Our Ref: 4795/JHHIP/20220927

27 September 2022

Re: Modification 2 Tree Clearing SSD-9351535-Mod-2 - Request for Additional Information

**FIGURE 2.1**  
**Biodiversity Features**

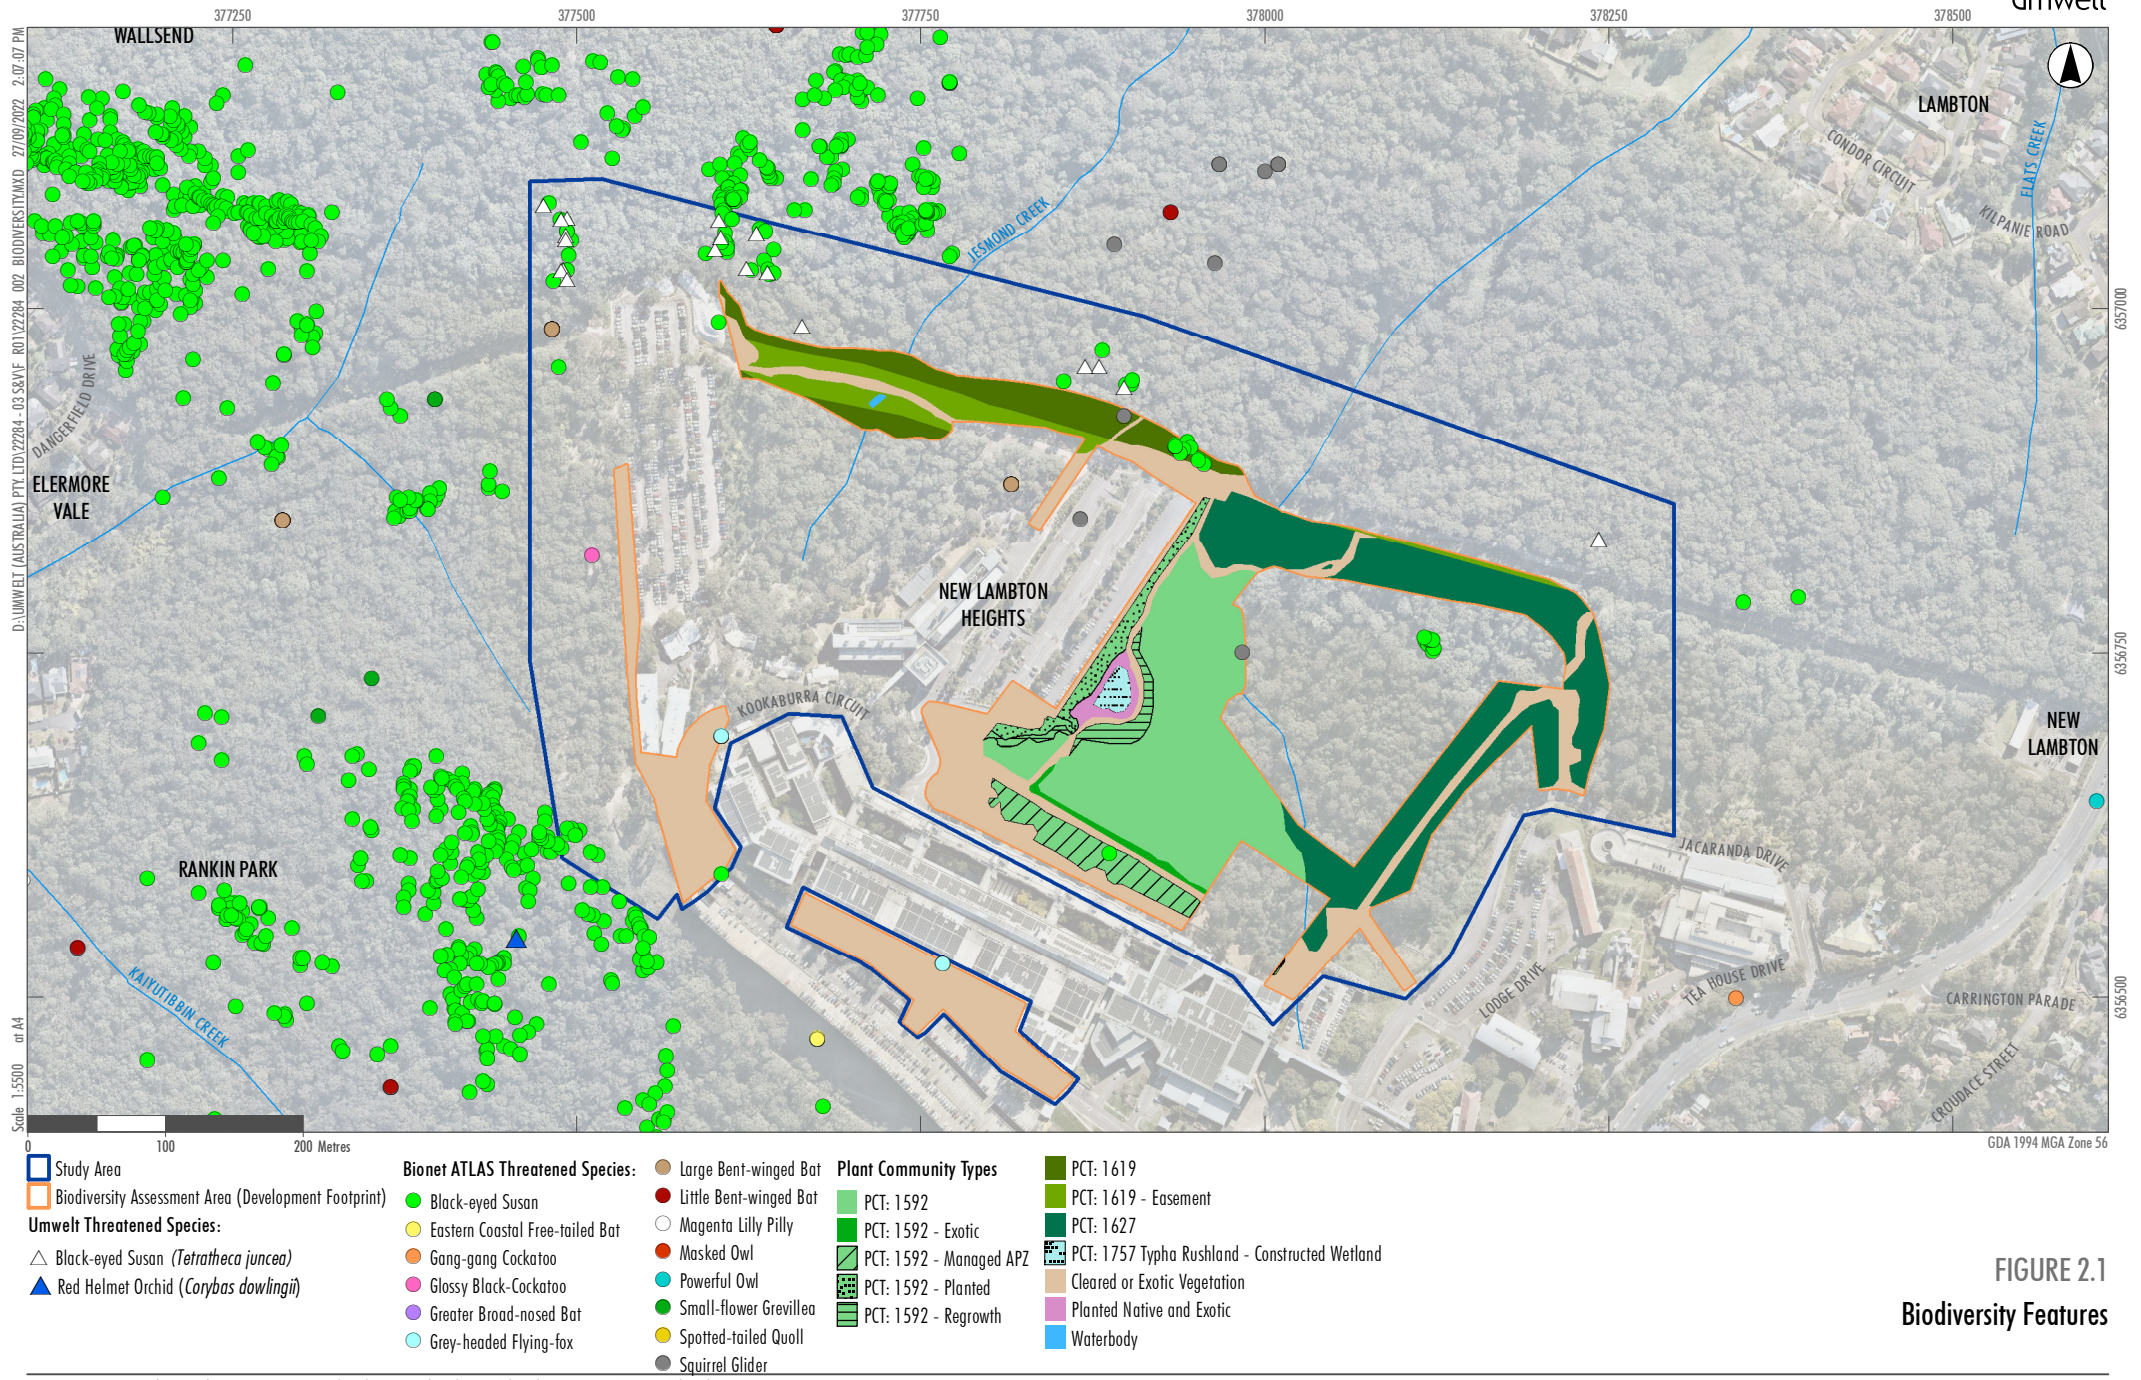
In response the BCD comments an updated version of the Biodiversity Management Plan is provided (see attached document). The location of red helmet orchid (*Corybas dowlingii*) that was recorded by BCD staff in proximity, but outside the project area has been included on Figure 2.1 of the Biodiversity Management Plan. No other changes were made, and the Plan has been forwarded separately.
